RE: SE-25-00019, Schmaus
SR 970 milepost 4.99 – milepost 5.12 right.

We have reviewed the proposed project and have the following comments.

Stephen P. (Phil) Nugent
Region Planning Manager

SCHMAUS RESIDENCE
 SCHMAUS HAUS, LLC
 SITE PLAN

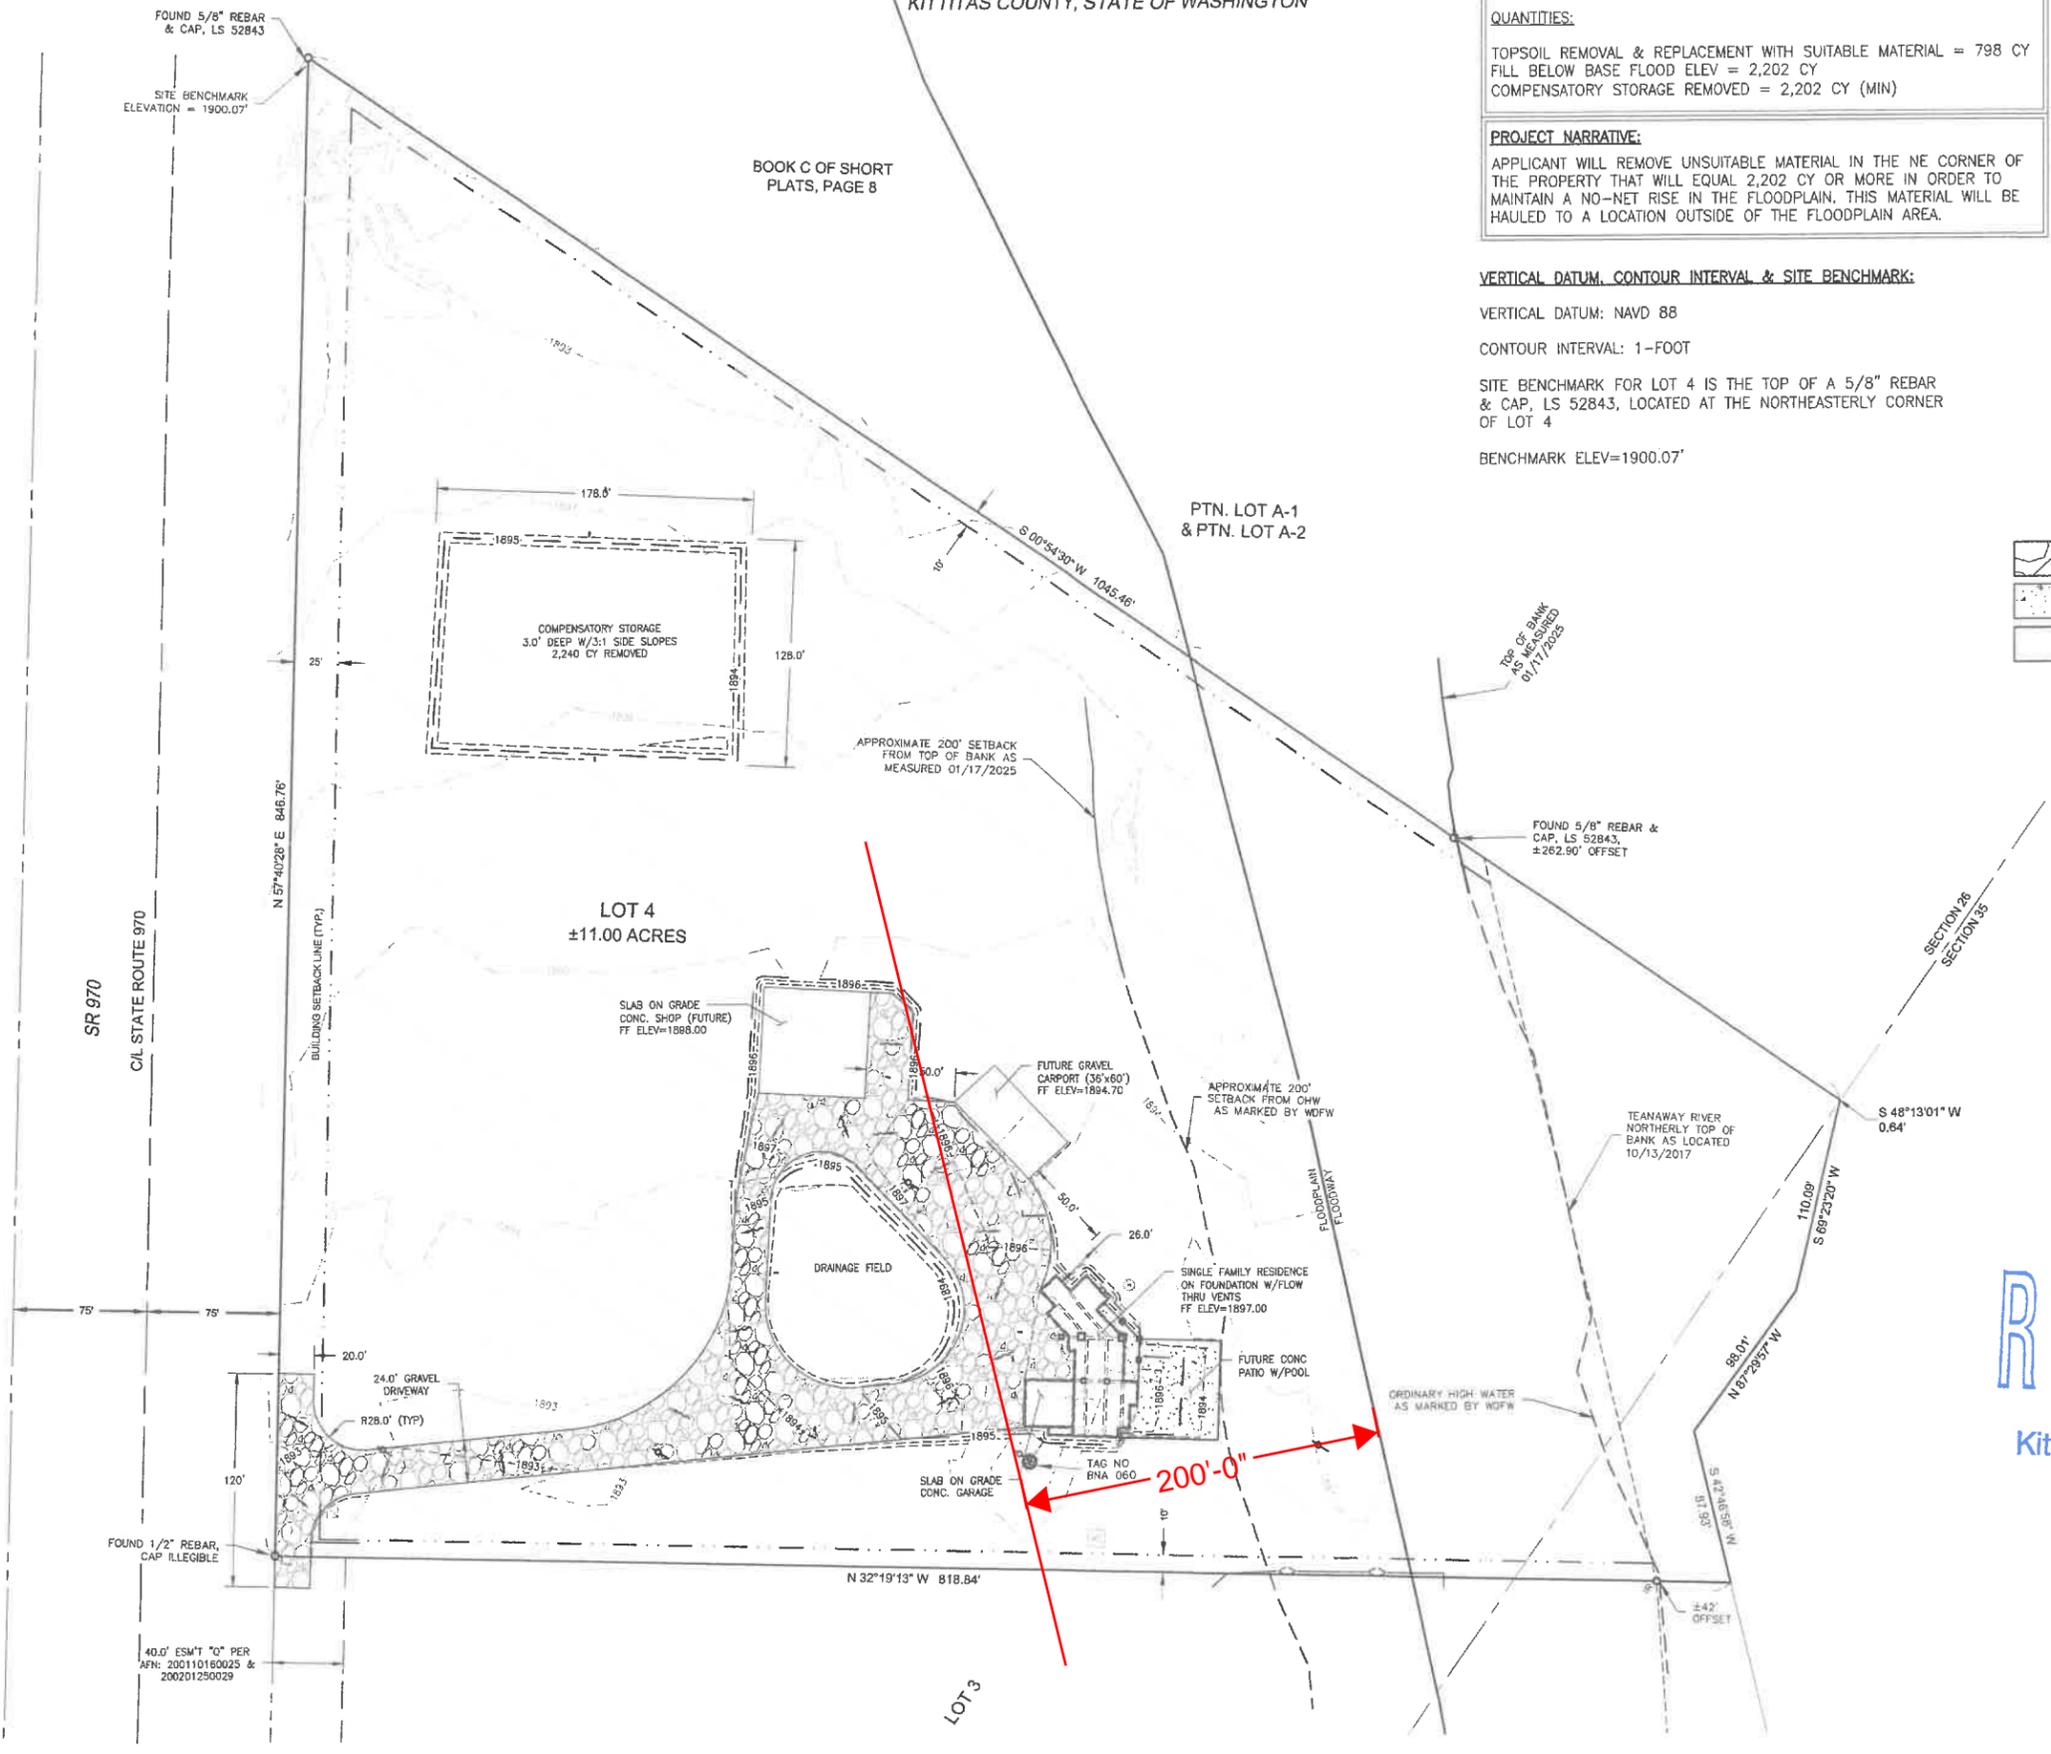
- The subject property is adjacent to State Route 970 (SR 970), a Managed Access Class 1 highway with a posted speed limit of 60 miles per hour. Access to the property is via the permitted joint-use connection at milepost 4.83 right (ACP 47283). No additional access will be permitted.
- Any proposed lighting must be directed down towards the site and away from SR 970.
- Stormwater or surface runoff generated by this proposal must be retained and treated on site. An approved utility permit is required for any discharge of water onto SR 970 right-of-way.
